Memorandum

To: Robert Lucero, Development Hearing Officer
From: Charlene Johnson, AICP, Senior Planner and Jim Strozier, FAICP, Principal
Date: October 20, 2025
Re: Final Plat Submittal _ PR-2023-009652 / SD-2025-0008

On February 12, 2025, the DHO approved a Preliminary Plat for the property located at the corner of Avenida de Jaimito and Unser Boulevard. This memo accompanies the Final Plat application to the DHO for review of compliance with the conditions of the Notification of Decision per IDO Section 6-6(L)(3)(b). The following is the response to conditions that are noted on the Final Plat.

**TRACT 1A
A REPLAT OF
THE WESTERLY PORTION OF TRACT 1
SUMMARY PLAT, 68.75 ACRE TRACT
& 66.15 ACRE TRACT
PARADISE HILLS, TOWN OF ALAMEDA GRANT,
CITY OF ALBUQUERQUE, BERNALILLO COUNTY,
NEW MEXICO
JULY, 2024**

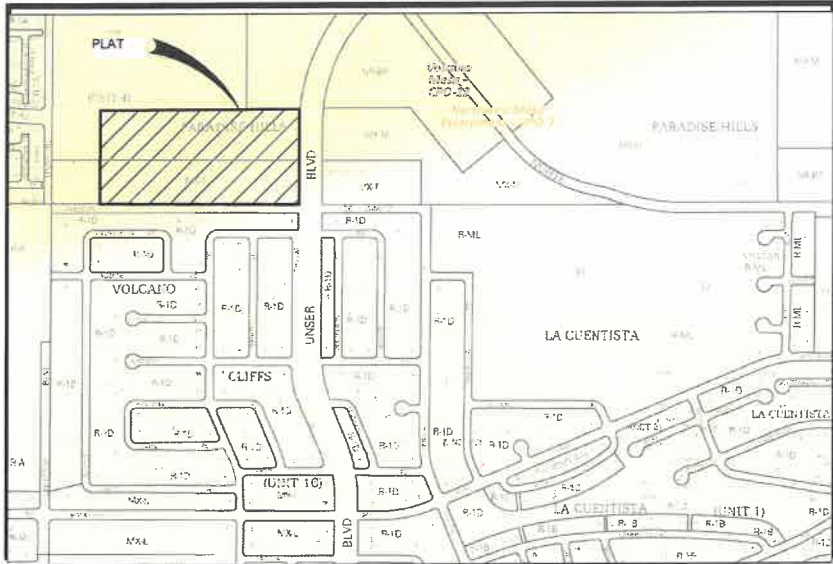
- c) *Project and application numbers must be added to the Plat.*

- d) *The name/title of the Plat must be clarified prior to the acceptance of the Final Plat and placement on a DHO agenda.*

Applicant Response: The project and application numbers were added to the Plat. General note #5 was also added that includes Sidewalk Waiver number and the date of approval.

Applicant Response: The title was modified to add clarifying detail. The title on the Final Plat is "TRACT 1A - A REPLAT OF THE WESTERLY PORTION OF TRACT 1 SUMMARY PLAT, 68.75 ACRE TRACT & 66.15 ACRE TRACT PARADISE HILLS, TOWN OF ALAMEDA GRANT, CITY OF ALBUQUERQUE, BERNALILLO COUNTY, NEW MEXICO"

**TRACT 1A
A REPLAT OF
THE WESTERLY PORTION OF TRACT 1
SUMMARY PLAT, 68.75 ACRE TRACT
& 66.15 ACRE TRACT
PARADISE HILLS, TOWN OF ALAMEDA GRANT,
CITY OF ALBUQUERQUE, BERNALILLO COUNTY,
NEW MEXICO**

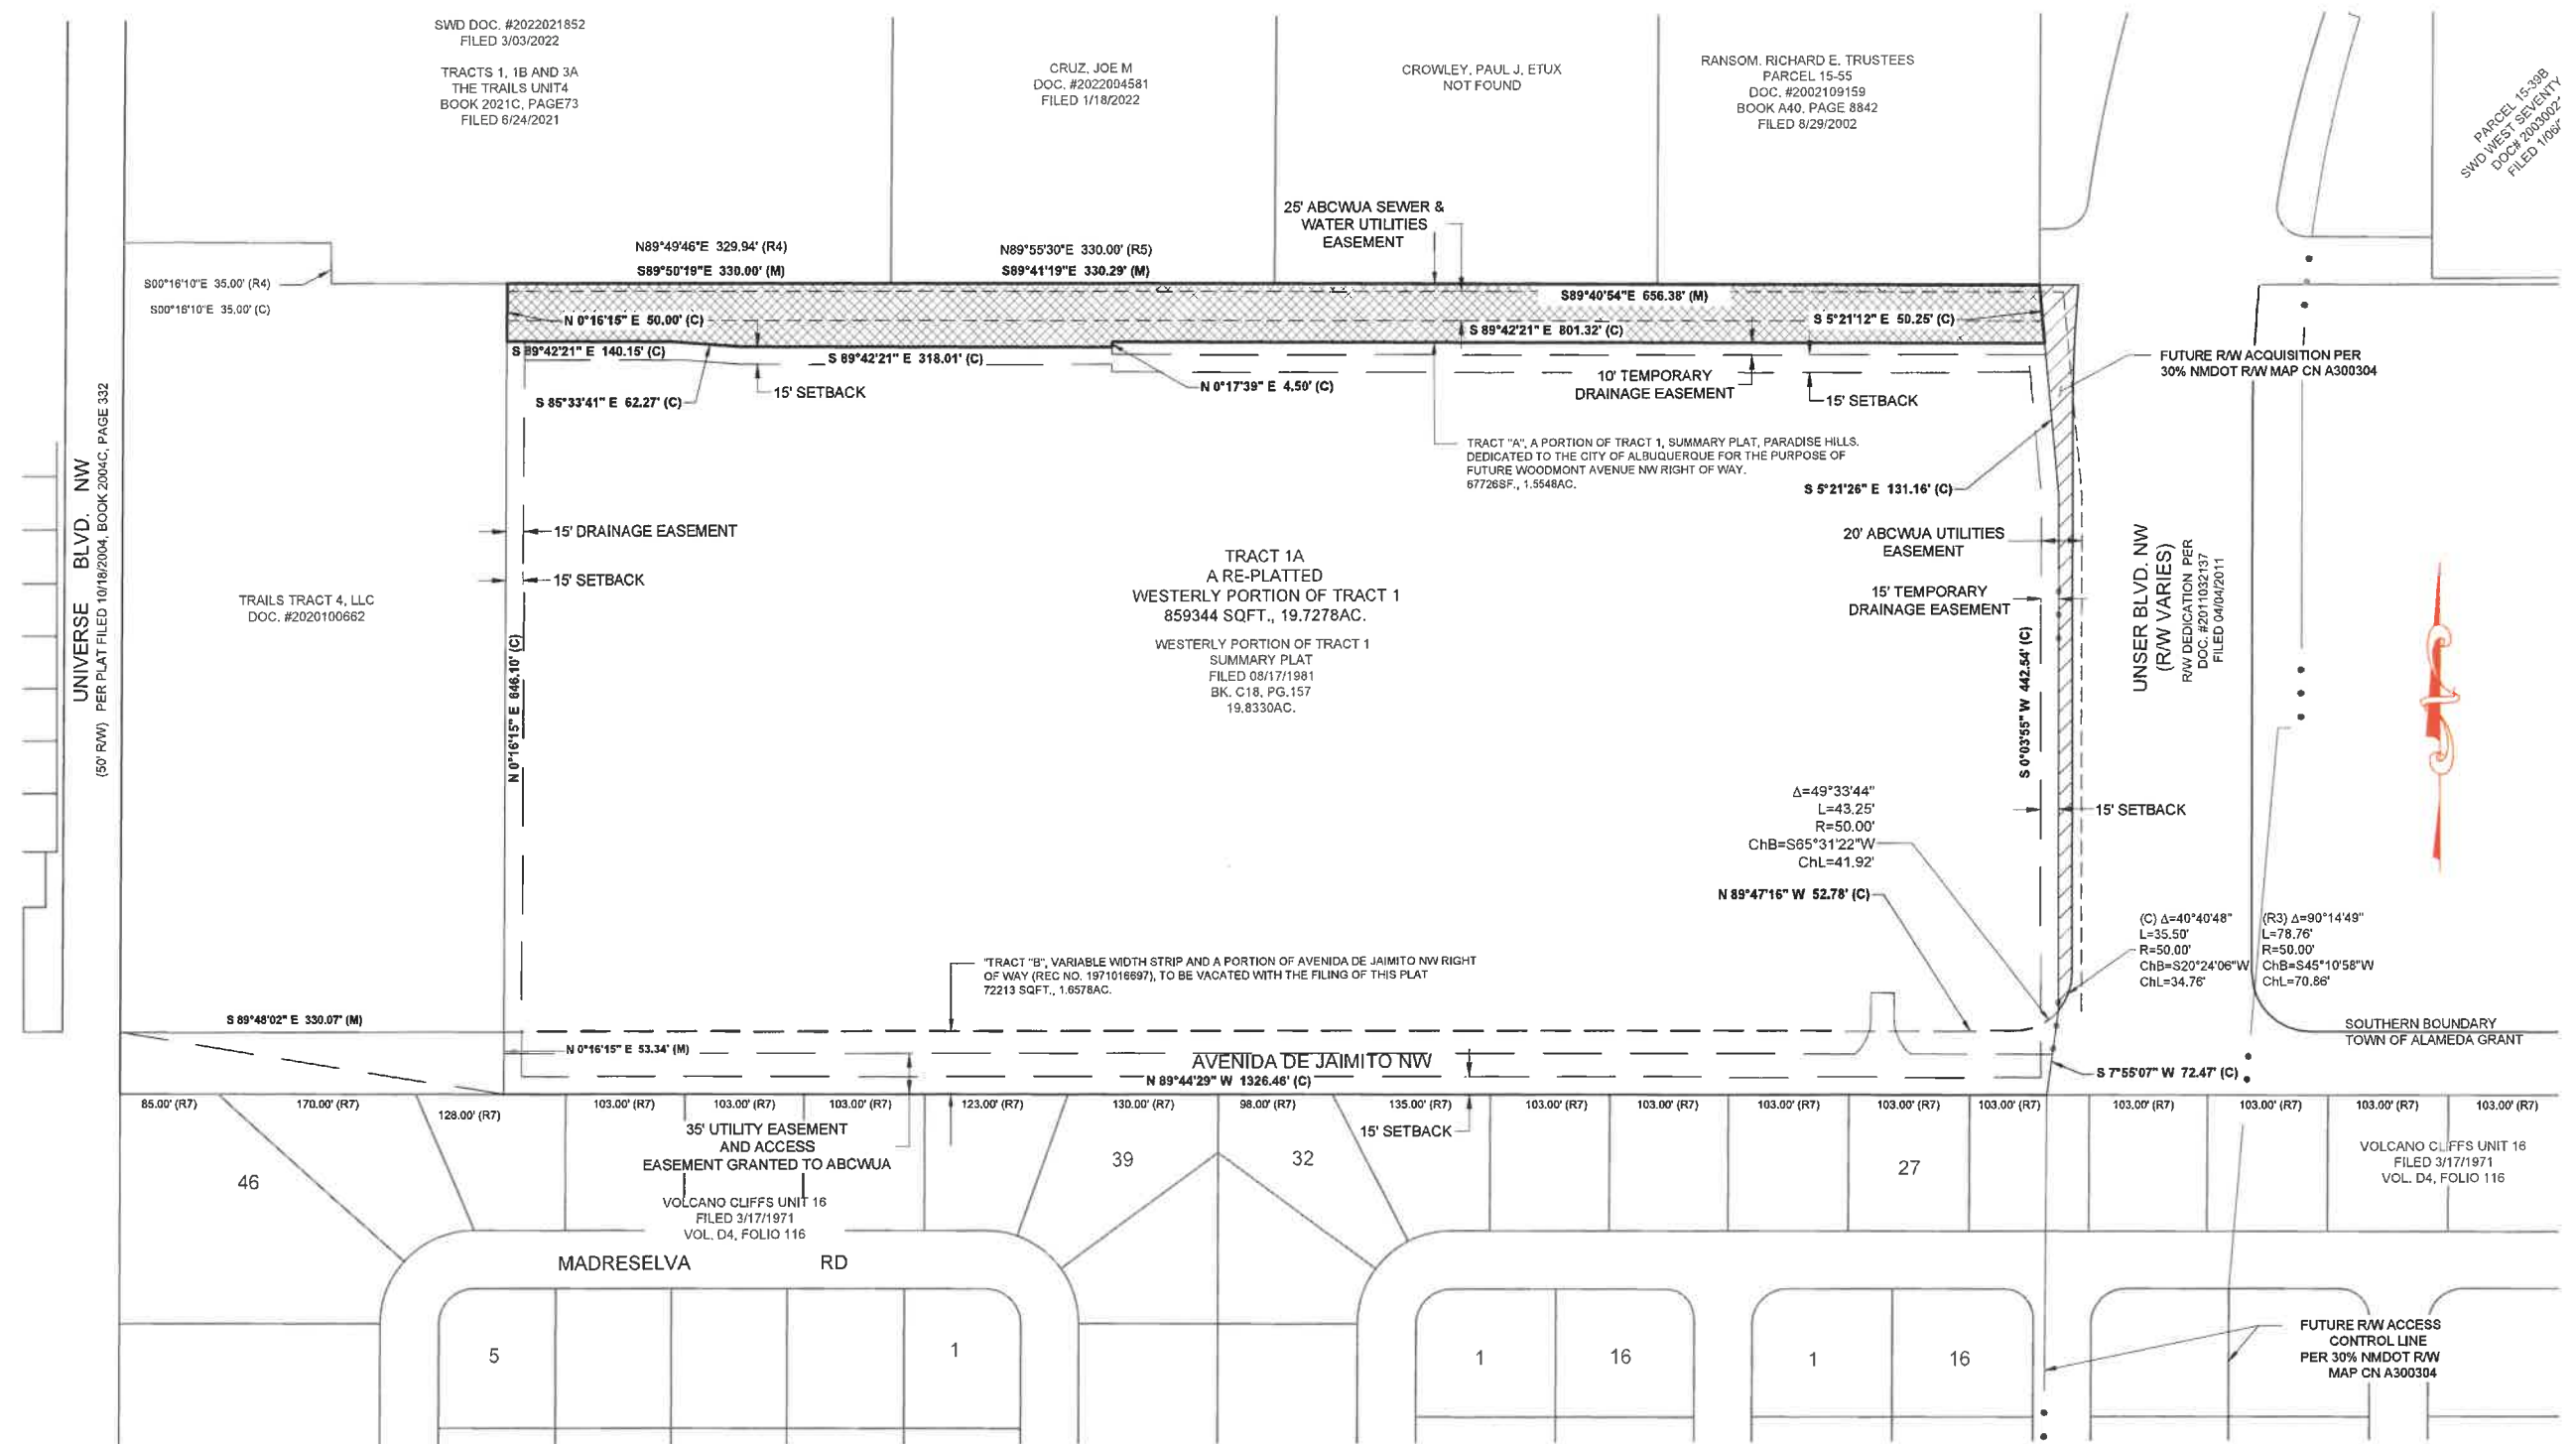
- a) *Revise the easement geometry designated for the turnaround to include 40-foot radius at both corners entering the easement.*

- b) *Change the language of the proposed easement to include a public waterline easement as well and remove the generic term for utilities to make this exclusive to public water and public sanitary sewer along this corridor regarding underground utilities.*

Applicant Response: Completed. The easement shows a 40-foot turnaround at both corners.

Applicant Response: Completed. An additional note was added to identify easements at Woodmont Avenue and at Unser Boulevard per discussions with David Guiterrez.
